From: [REDACTED]
Sent: 12 April 2012 11:15
To: lwrightman@chichester.gov.uk
Cc: Anita Gardner
Subject: The Old Barn - Ferring - Application No. FG/6/12 & FG/4/12/L
Attachments: Drawing 3214-006 Rev C.pdf, Drawing 3214-009 Rev E.pdf, Drawing 3214-010 Rev E.pdf, Drawing 3214-011 Rev D.pdf

RE: The Old Barn - Ferring - Application No. FG/6/12 & FG/4/12/L

Further to yesterday's telephone discussion, please find attachments with Febo Designs revised drawings No's 3214-006 rev C, 3214-009 Rev E, 3214-010 Rev E and 3214-011 Rev D.

DRAWING NO. 3214-009

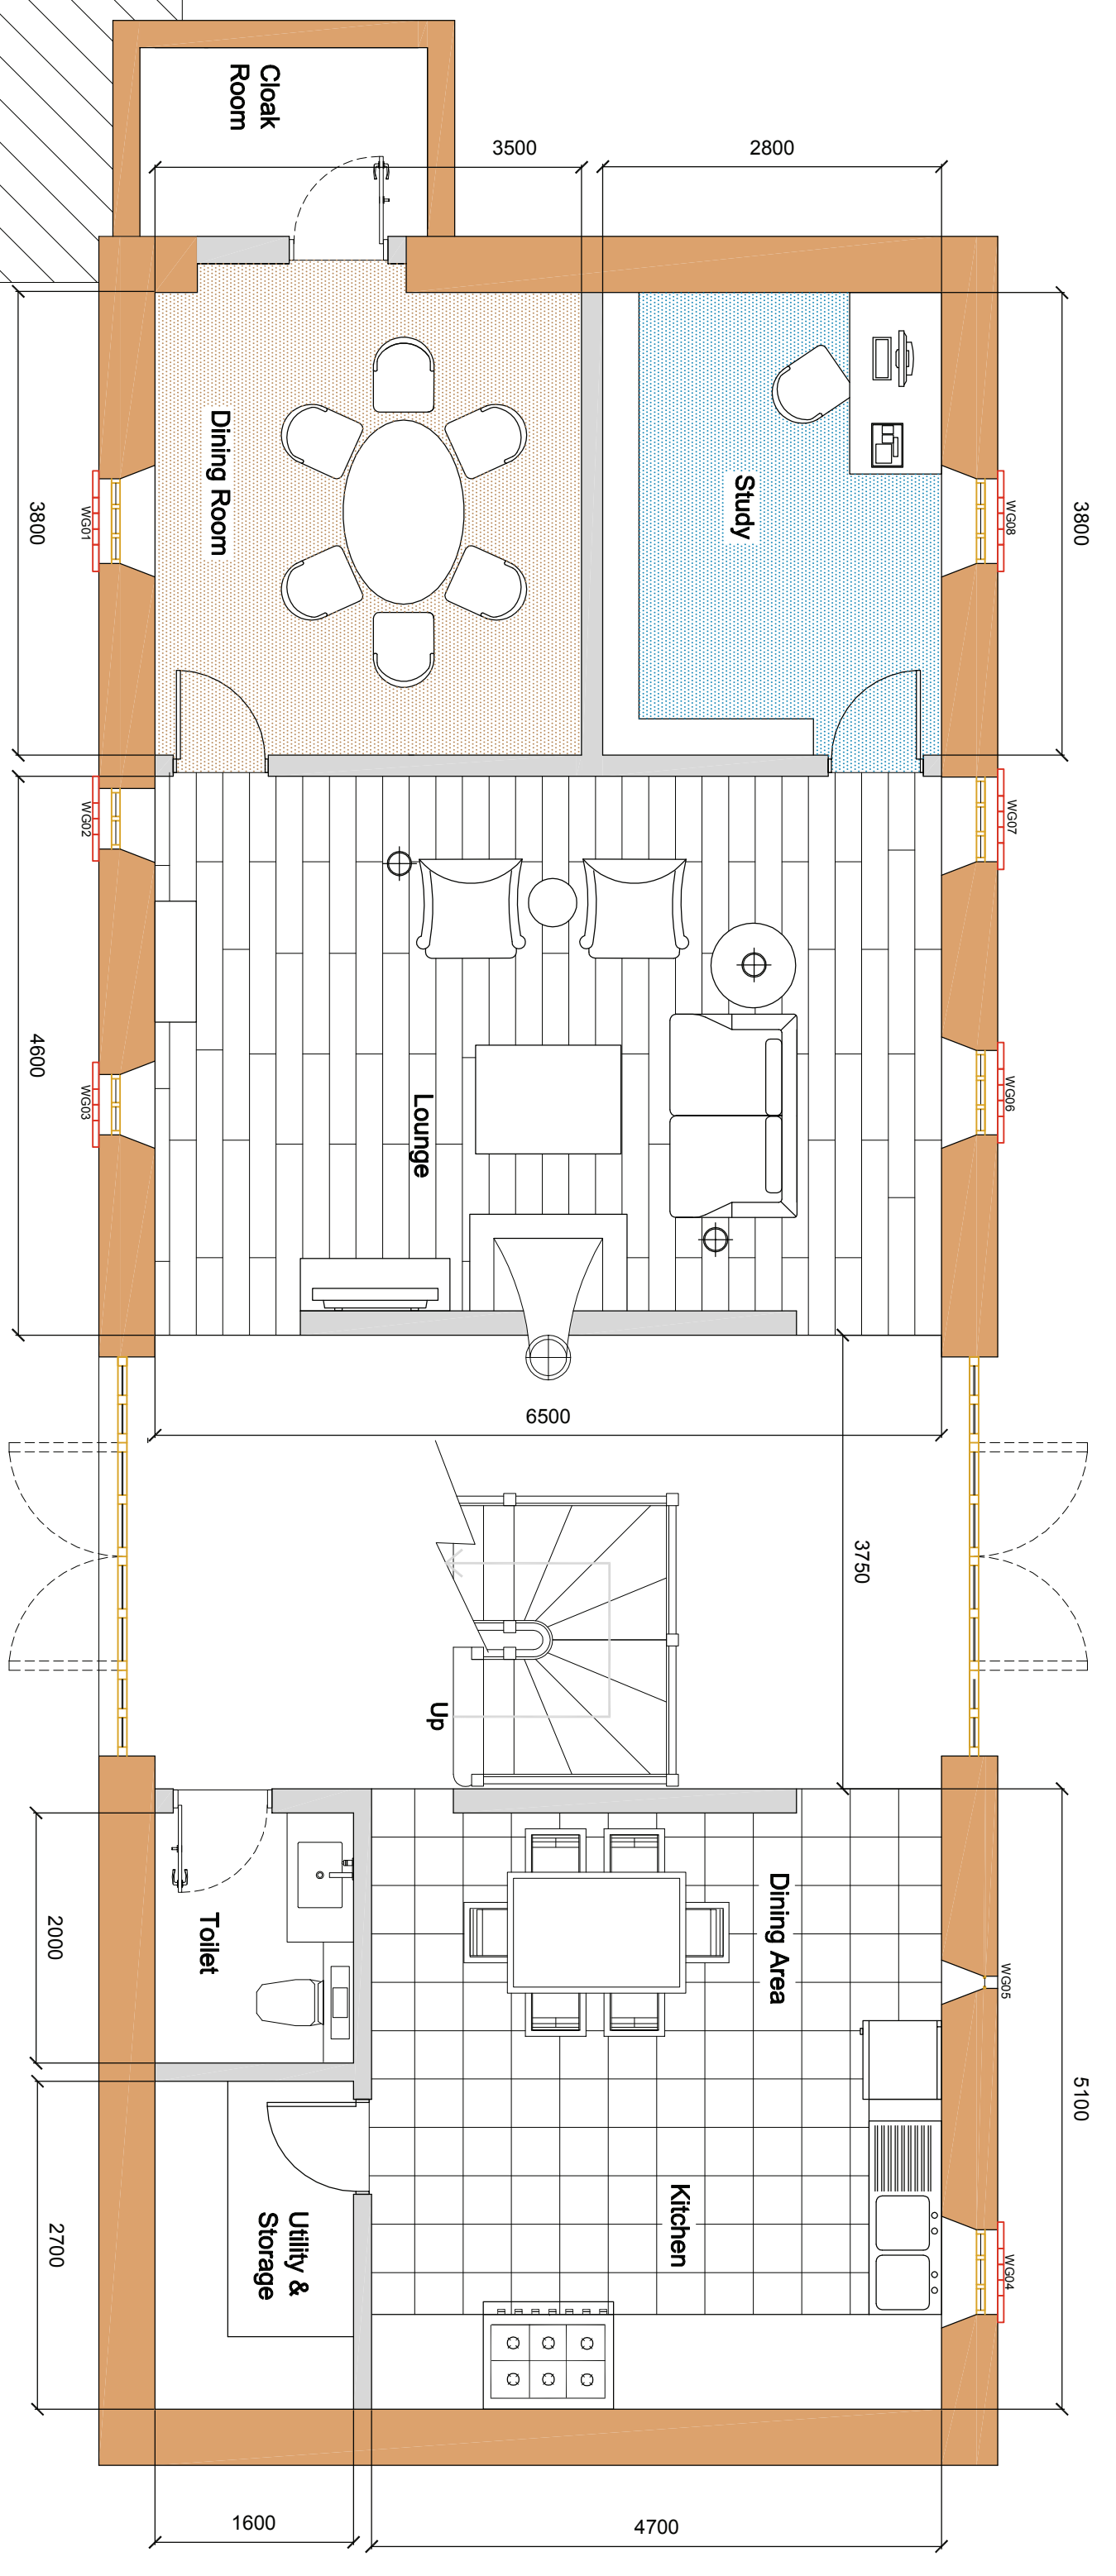
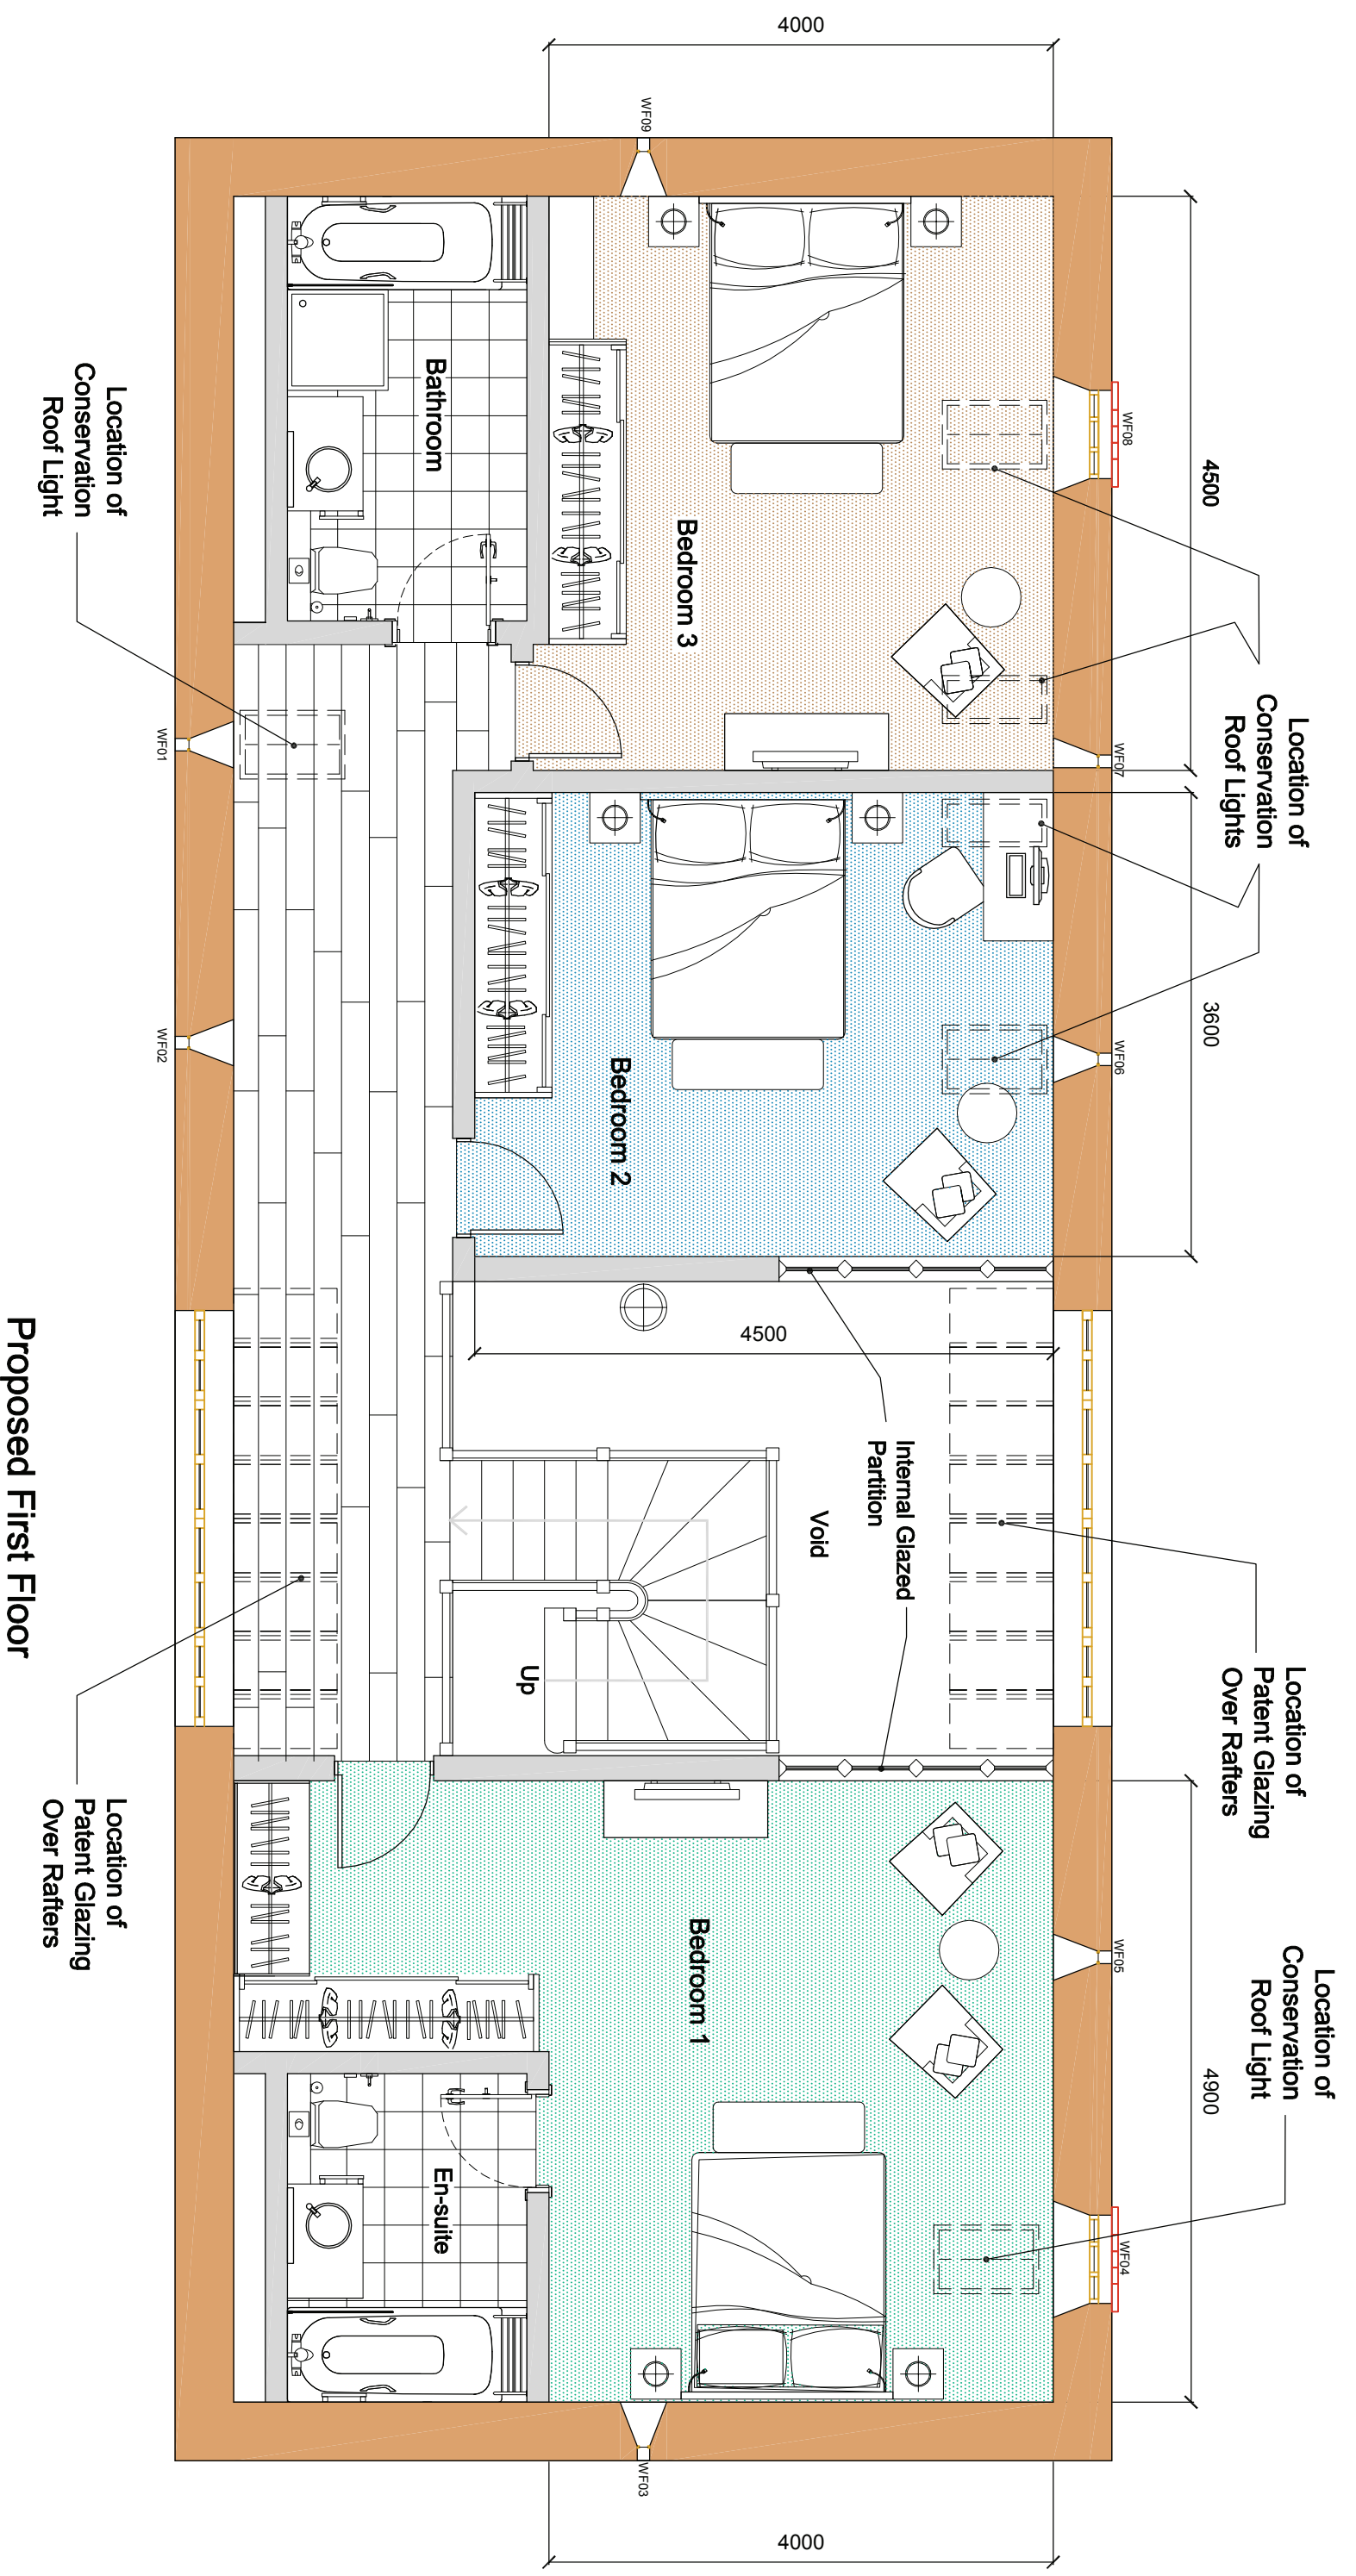
1. The Patent Glazing over the west entrance has been removed
2. The internal glazing to Bedroom 2 has been extended
3. The Study's partitions have been chaged from solid to glazed construction
